Your reference: 1010349 P1
Our reference: SF13/580

**Re: Orica Southlands Remediation & Warehouse Development Project
Modification Application (MP 06-0191 Mod 1)**

I refer to your letter of 3 March 2013 regarding Orica Australia Pty Ltd's (Orica) application to modify the approval for the Orica Southlands Remediation & Warehouse Development Project. We have reviewed DBL Property's letter of 26 February 2013 relating to the proposed modification and provide the following comments.

Lot Area Schedule	
	Approx Area
Lot 1	2.80 ha
Lot 2	2.43 ha
Lot 3	1.05 ha
Lot 4	0.91 ha
Lot 5	0.99 ha
Lot 6	1.21 ha
Lot 7	1.44 ha
Lot 8	1.16 ha
Lot 9	5.44 ha
Lot 10	Orica pipeline Lot
Lot 11	Orica pipeline Lot

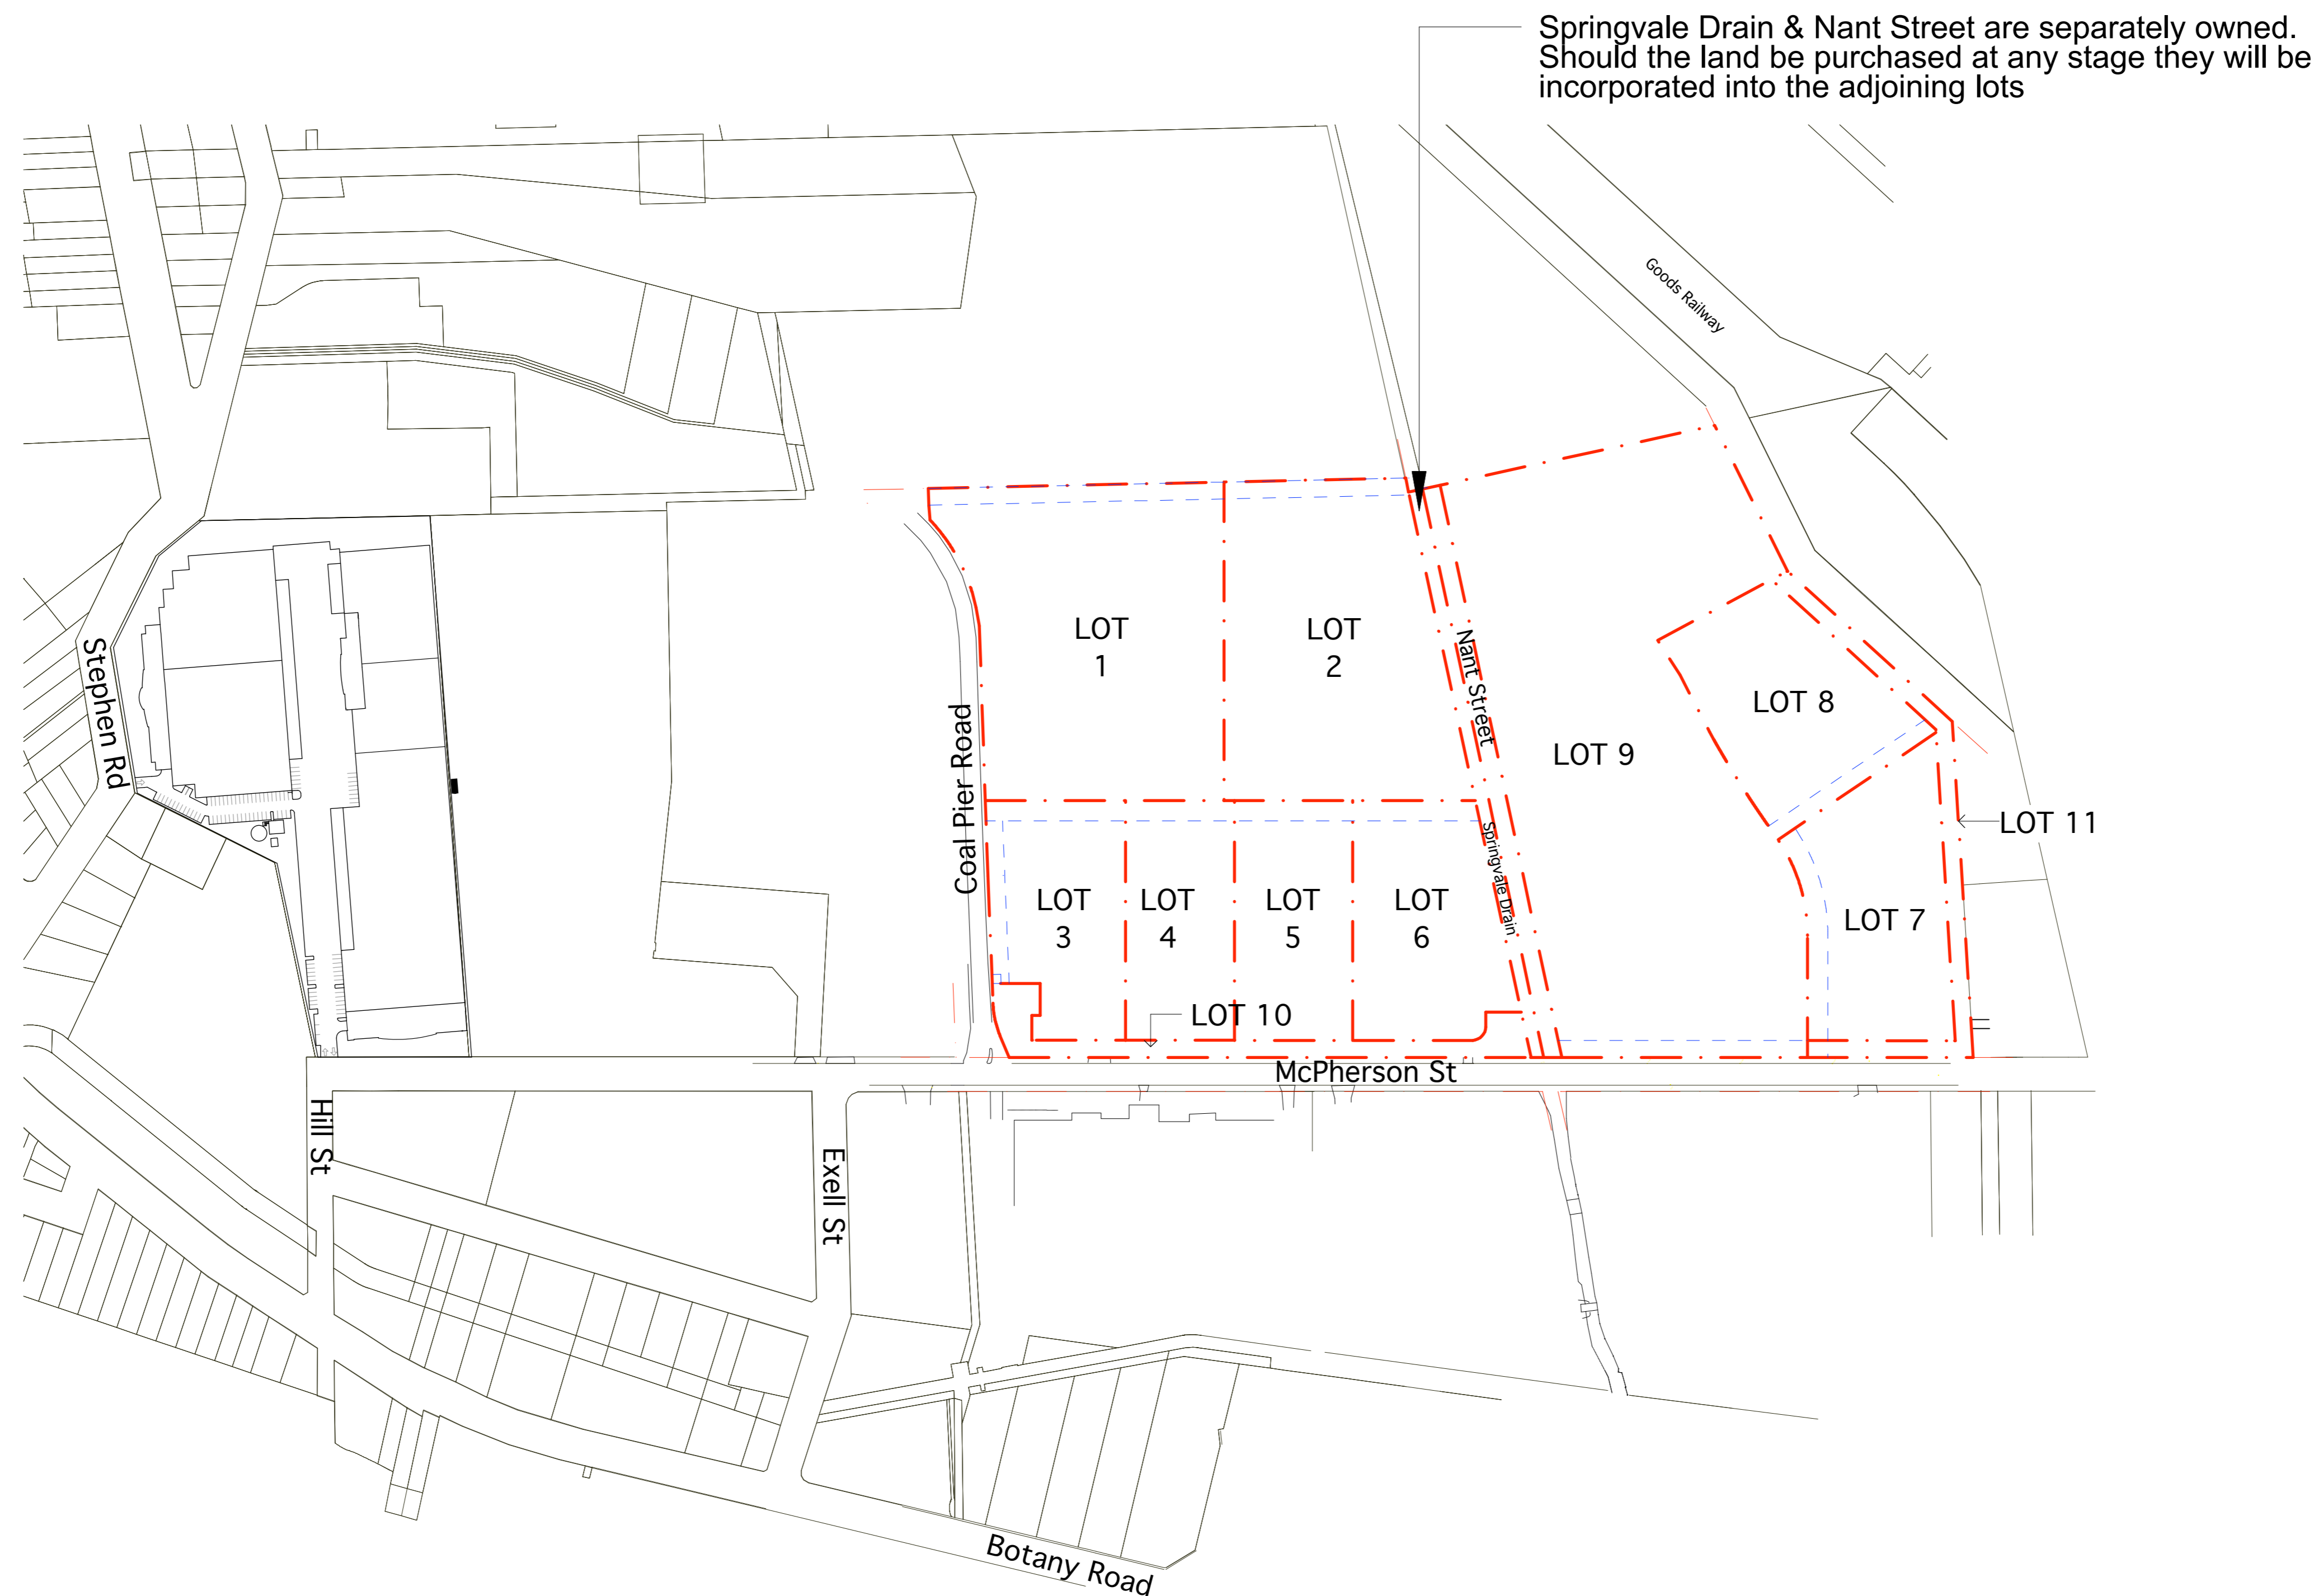
Groundwater Wells and Pipeline Easements – We understand that certain areas of land previously identified as easements to enable access to Orica's groundwater monitoring and containment infrastructure will now be created as two lots with ownership to be retained by Orica. These are identified as Lots 10 and 11 on the Proposed Easements diagram (No. SRD DA017 (F), dated 22 June 12) provided as part of the modification application.

Diagram No. SRD DA017 (F) indicates that some land will become easements at the newly proposed Lot 9 if that land is sold. An earlier version of the Proposed Easements diagram (No. SRD DA017 (D), dated 8 November 2010) indicates that additional easements were to be created at the newly proposed Lot 9 as part of the original easement proposal. Those proposed easements, identified as easements 3 and 4 and part of easements 8 and 9 on diagram No. SRD DA017 (D) do not appear to be included as part of the revised easement proposal.

It is recommended that the proponent be requested to provide further information on the removal of these areas from the easement proposal (e.g. explain how it is associated with the revised design of the compensatory flood basin) and how the loss of those easements may affect future groundwater monitoring/containment activities at Southlands.

Date	Datum	Scale	Size
JAN'13	AHD	1:1000	A1
Drawing Number: 210094-DA-001			Revision B

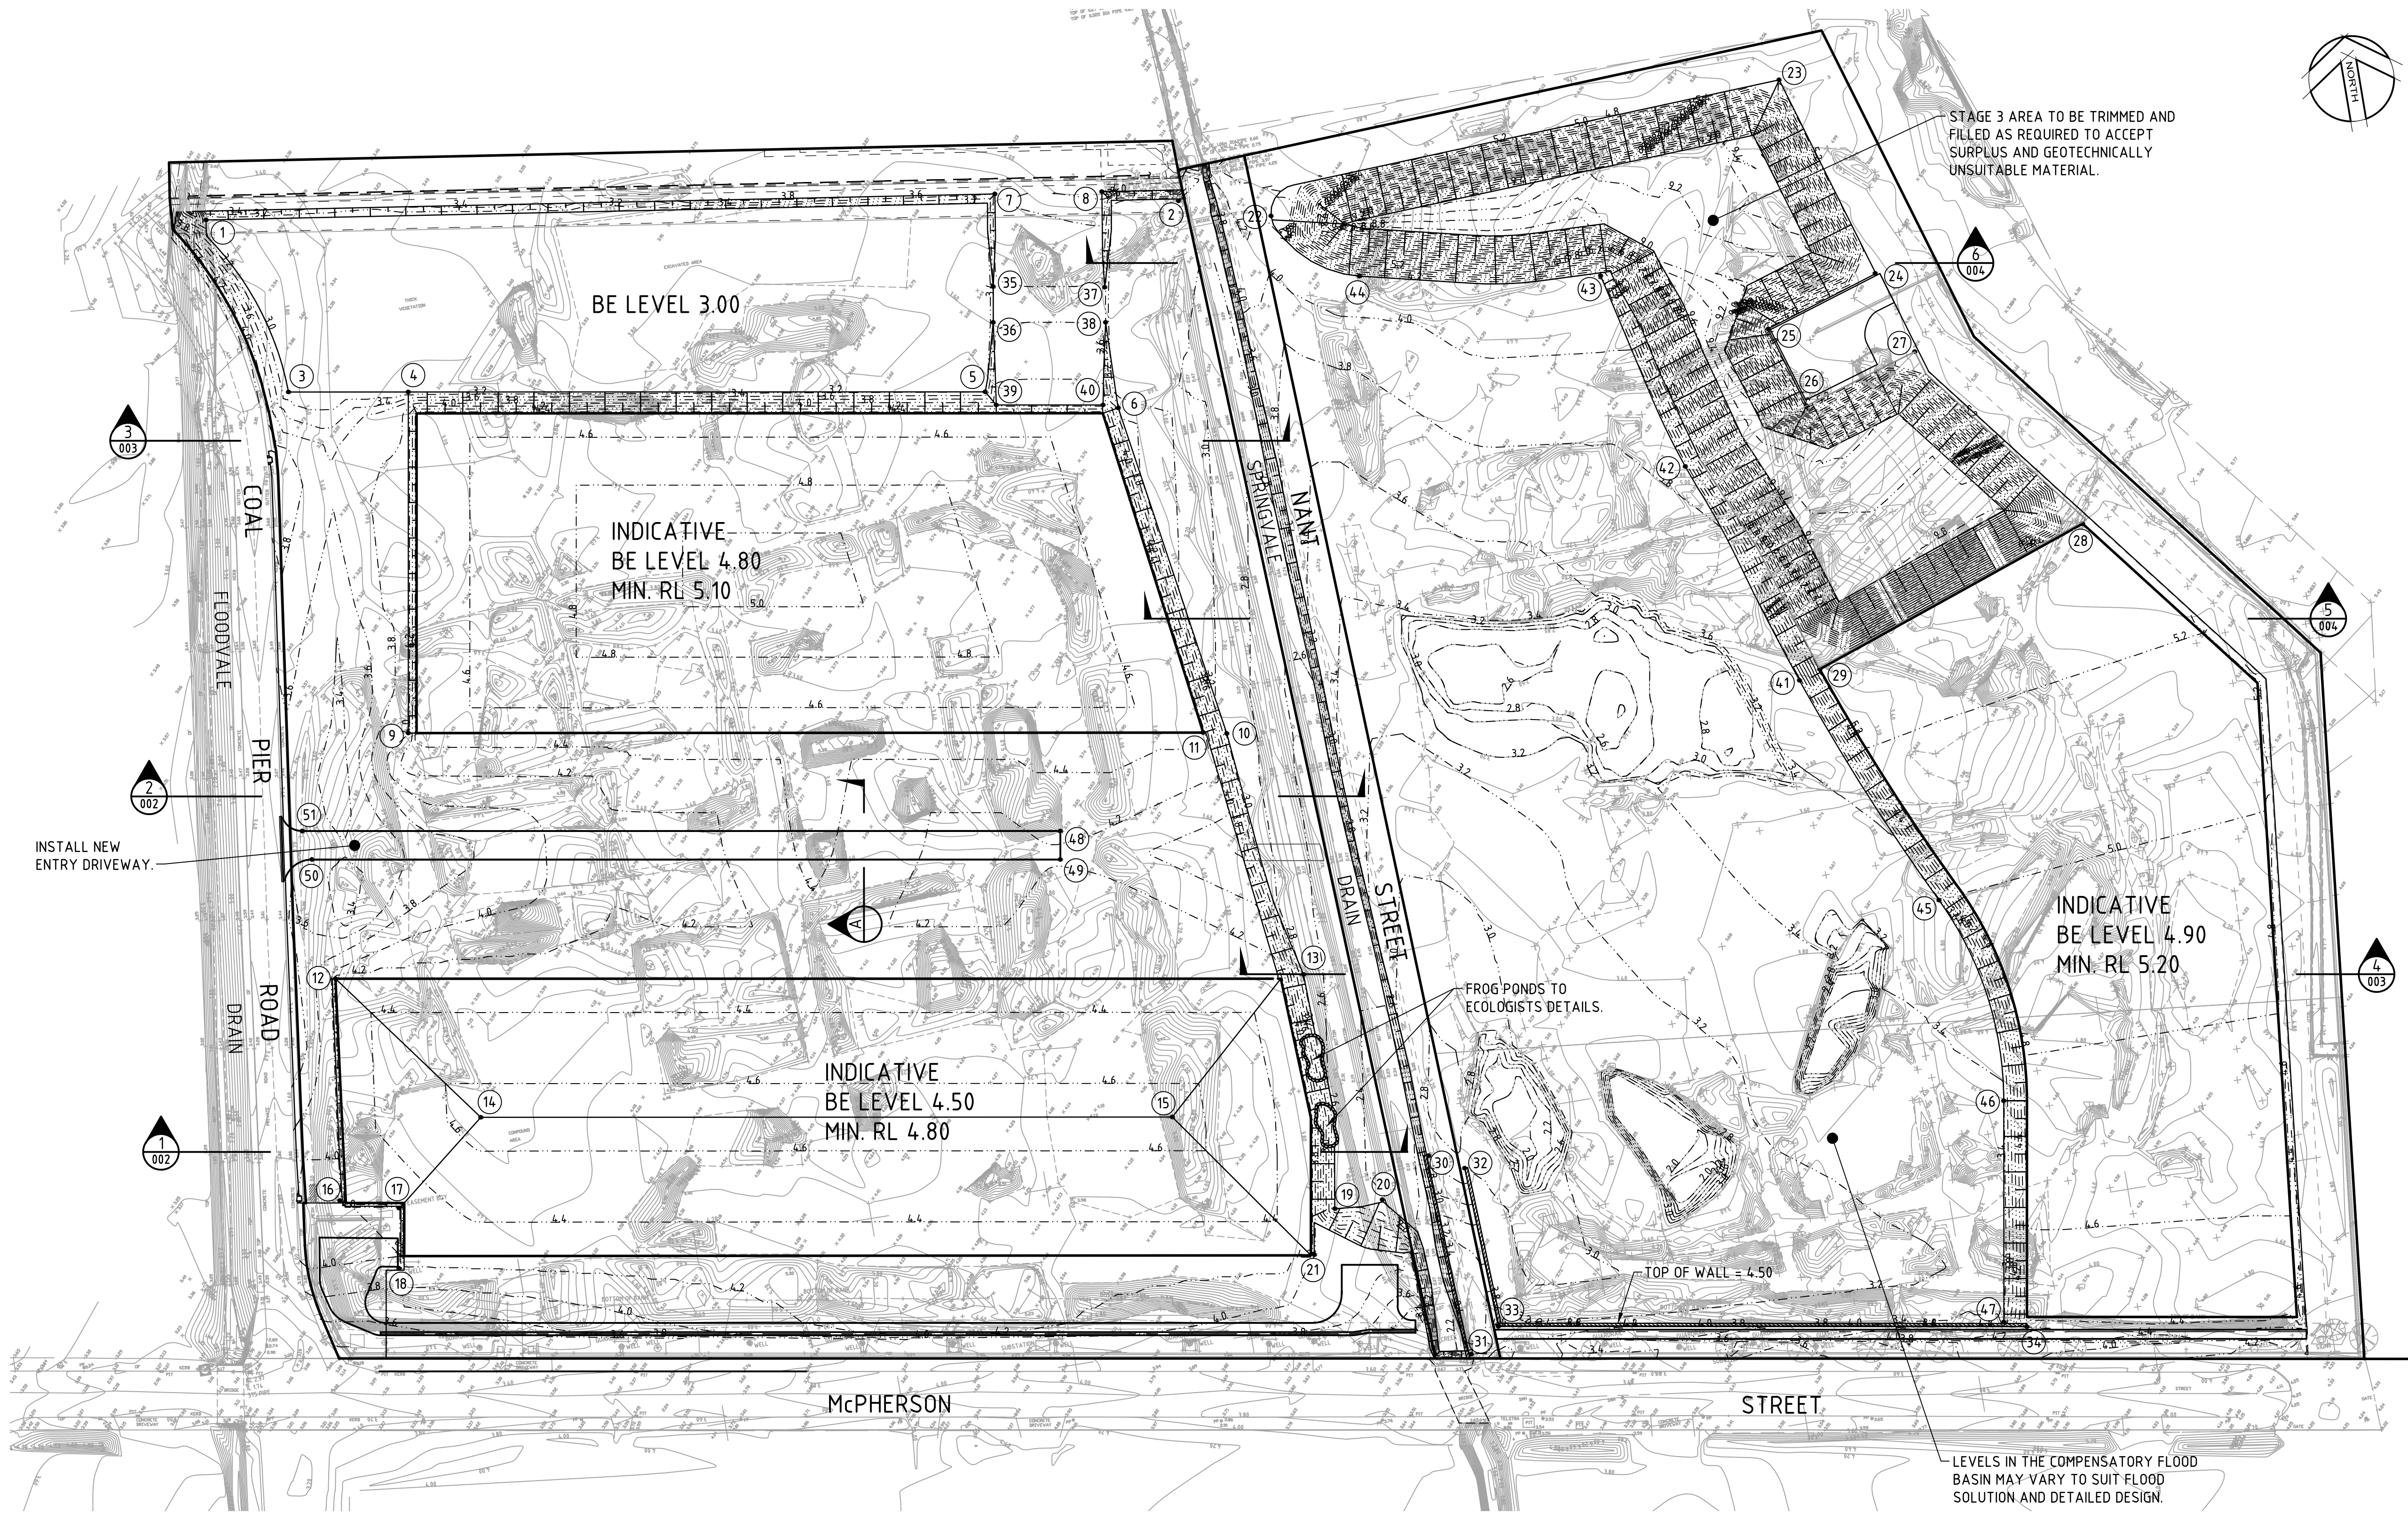
Compensatory Flood Basin – DBL Property's letter of 26 February 2013 states that the modified basin area will be configured to avoid any chance of unsuitable incursion of groundwater into the basin. The revised basin design takes into account recent investigations, including trenching to observe shallow groundwater levels, and advice from a hydrogeologist.

The EPA agrees that it is important to prevent contaminated groundwater entering the flood basin given that:

- Water within the basin would be expected to primarily discharge to Penrhyn Estuary; and
- The revised flood basin area appears to be closer to proposed warehouses 1, 2 and 6 (i.e. water within the basin must not represent a source of vapours that could pose an unacceptable risk to future site users).

We recommend that the proponent be requested to provide advice on how the storage of flood water within the basin is expected to affect the local hydrogeology (e.g. impacts on groundwater flow direction caused by potential groundwater mounding) and whether there will be any influence on hydraulic containment of the chlorinated hydrocarbon contaminant plumes at the Primary Containment Area. Orica may wish to provide the results of any studies conducted into this matter to support their advice.
